EN010085 - Application by Cleve Hill Solar Park Ltd for an Order Granting Development Consent for the Cleve Hill Solar Park

RE: Advice Following the Issue of Decision to Accept the Application for Examination

Table 1 - Applicant's Response to Inspectorate's Observations

Project Title

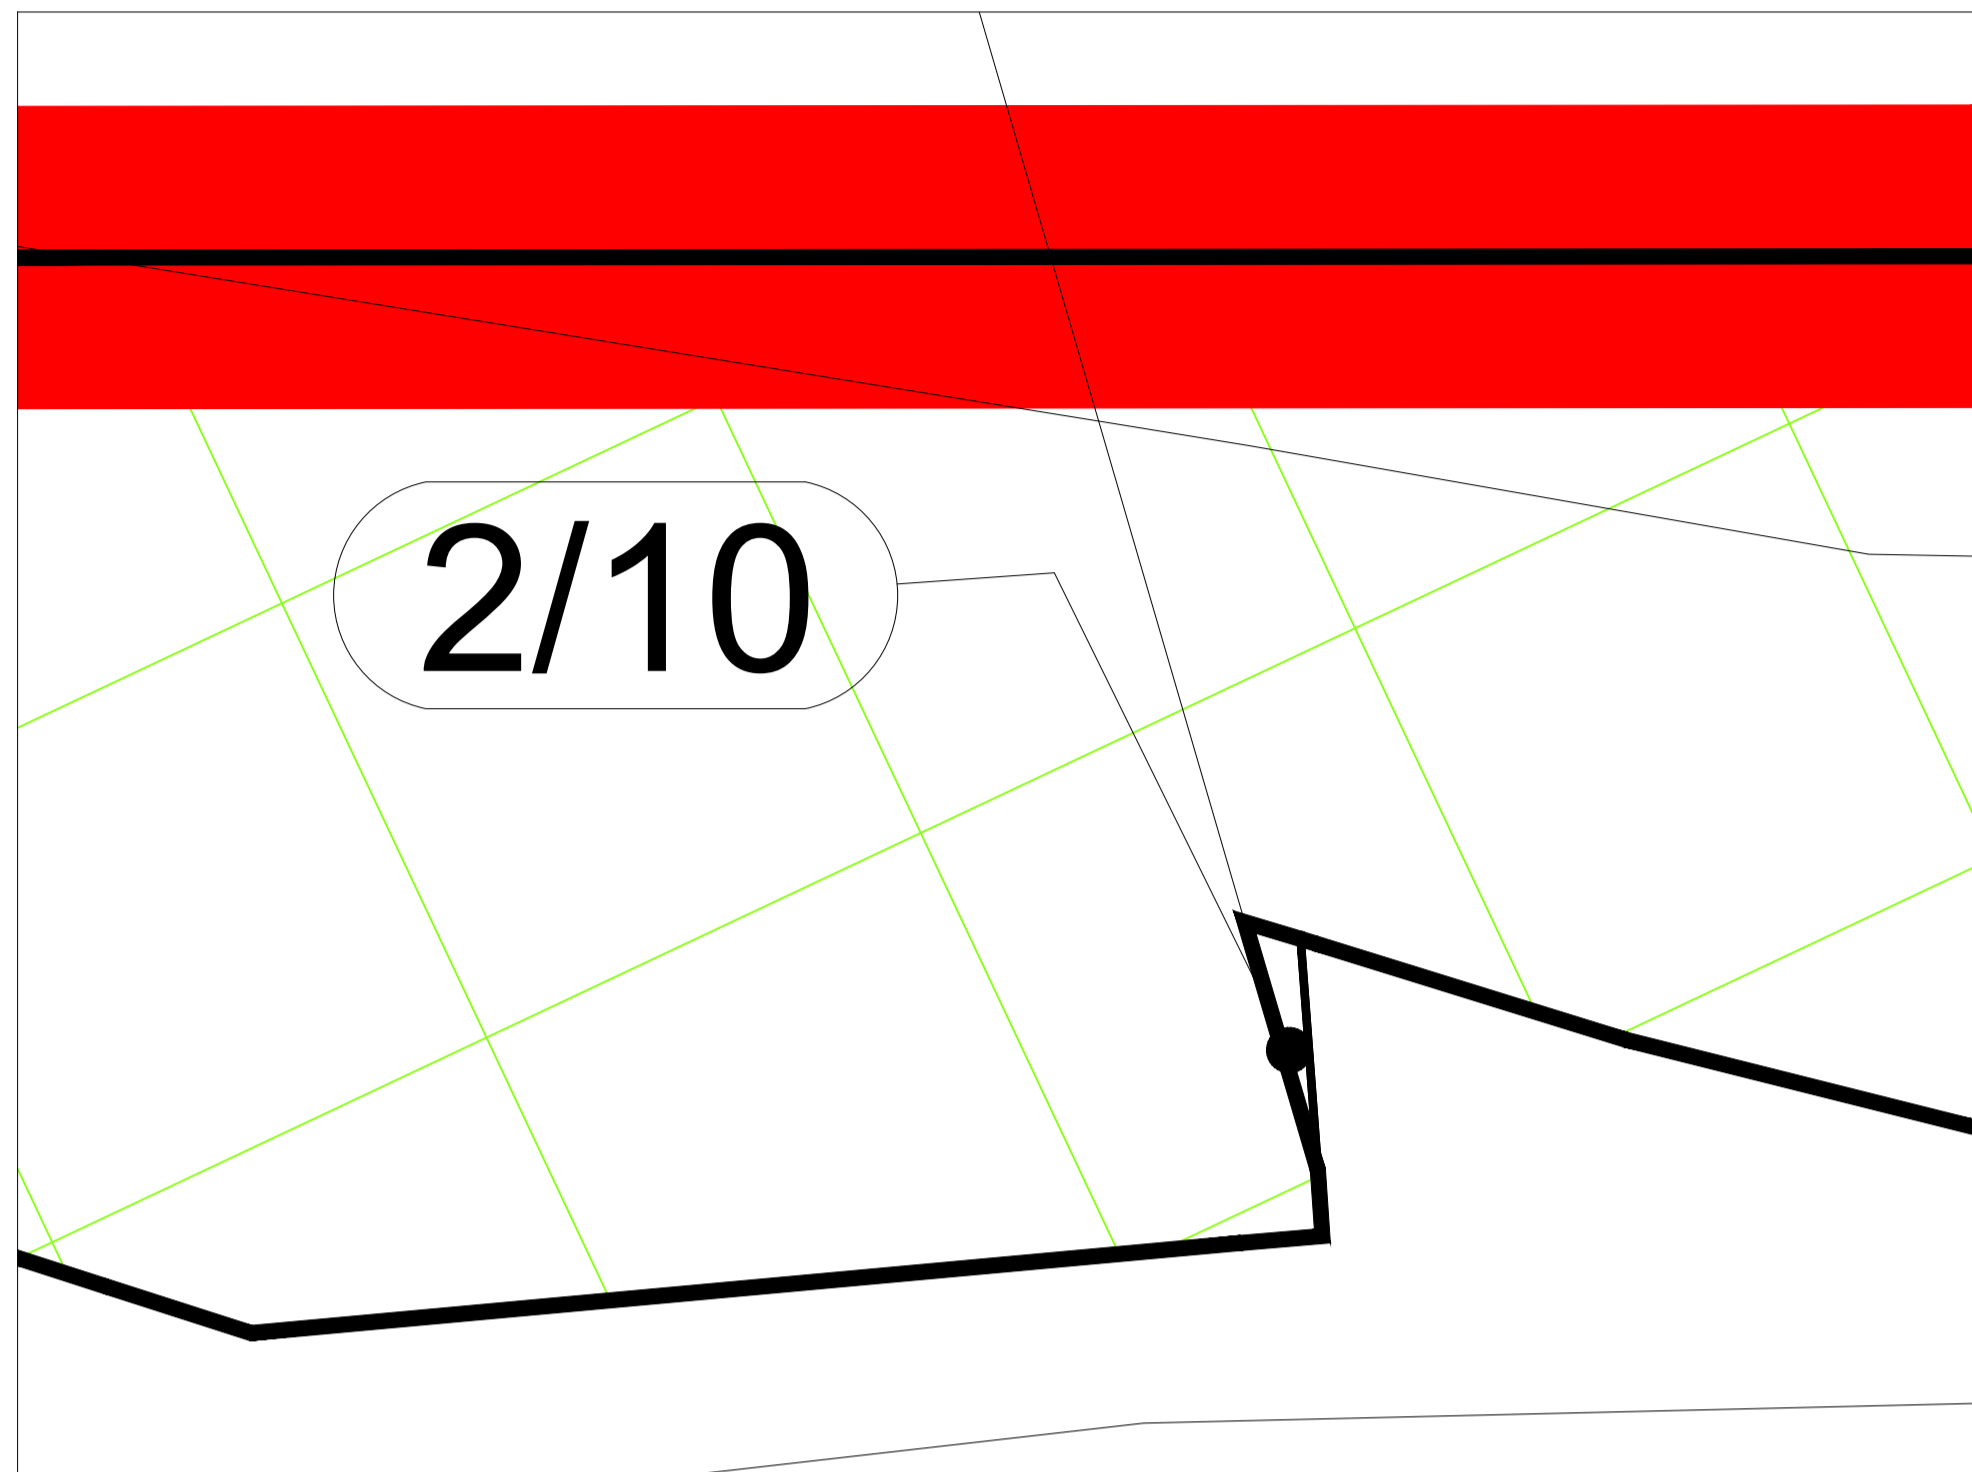
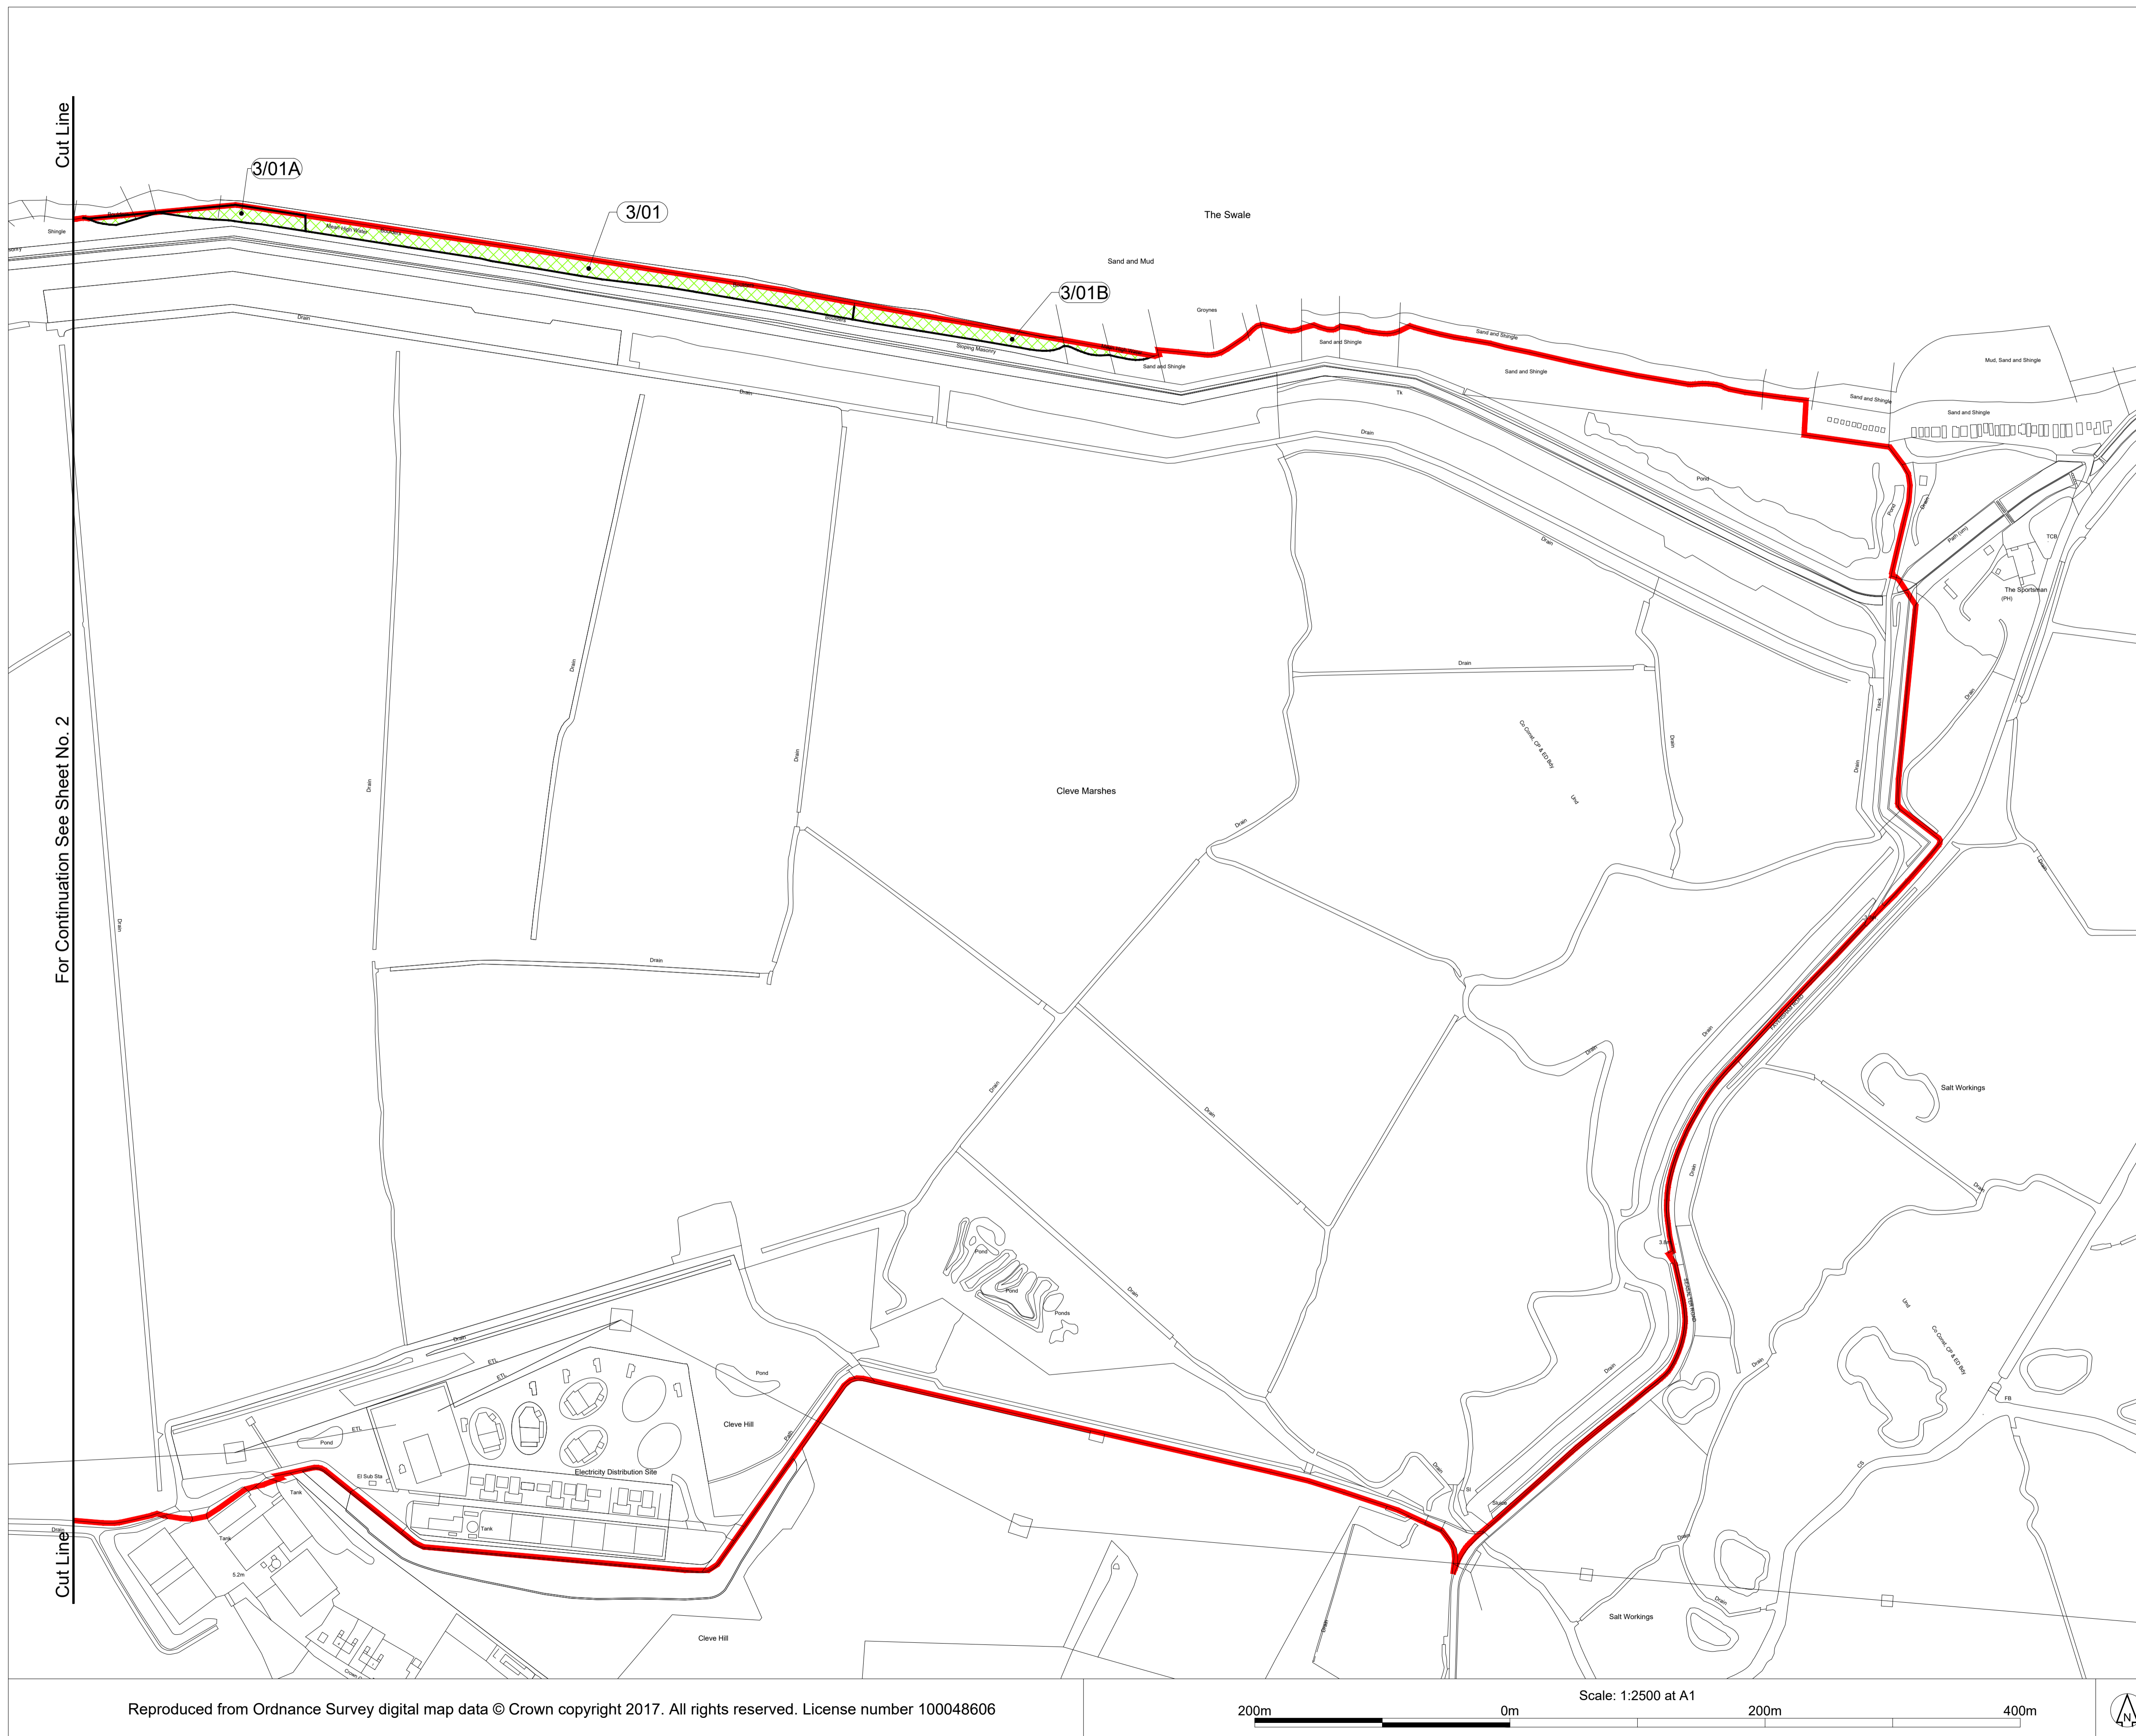
Distinction between start and end of given paths is unclear. Figure 3 shows paths ZR692 & CW90 as one complete footpath but there is no point at which one becomes the other (same for ZR484 & CW55).	The enclosed Rights of Way Plan has been updated to clearly show the start and end of given paths (doc 2.3, Revision B).
'Proposed Permissible Footpath' (as shown on Figure 3 of the Rights of Way plans (Doc Ref 2.3) does not appear to be cited in the dDCO.	This relates to the permissive path that is included in the authorised development. It is proposed that the public will have permissive access to the path, but it will not be designated as a PRoW/footpath. For that reason the permissive path is only included in Schedule 1 of the draft DCO under further associated development (f) " <i>permissive paths</i> ".
Crown Land Plans	
The Inspectorate has noted that the inset sections detailing the smaller plots (used on the land plans (Doc Ref 2.1)) are missing from the Crown Land plans. This can make seeing the affected plot difficult without also viewing the land plans. Please can the Applicant provide clarity on this.	Inserts have been added to the enclosed Crown Land Plan (Revision B).
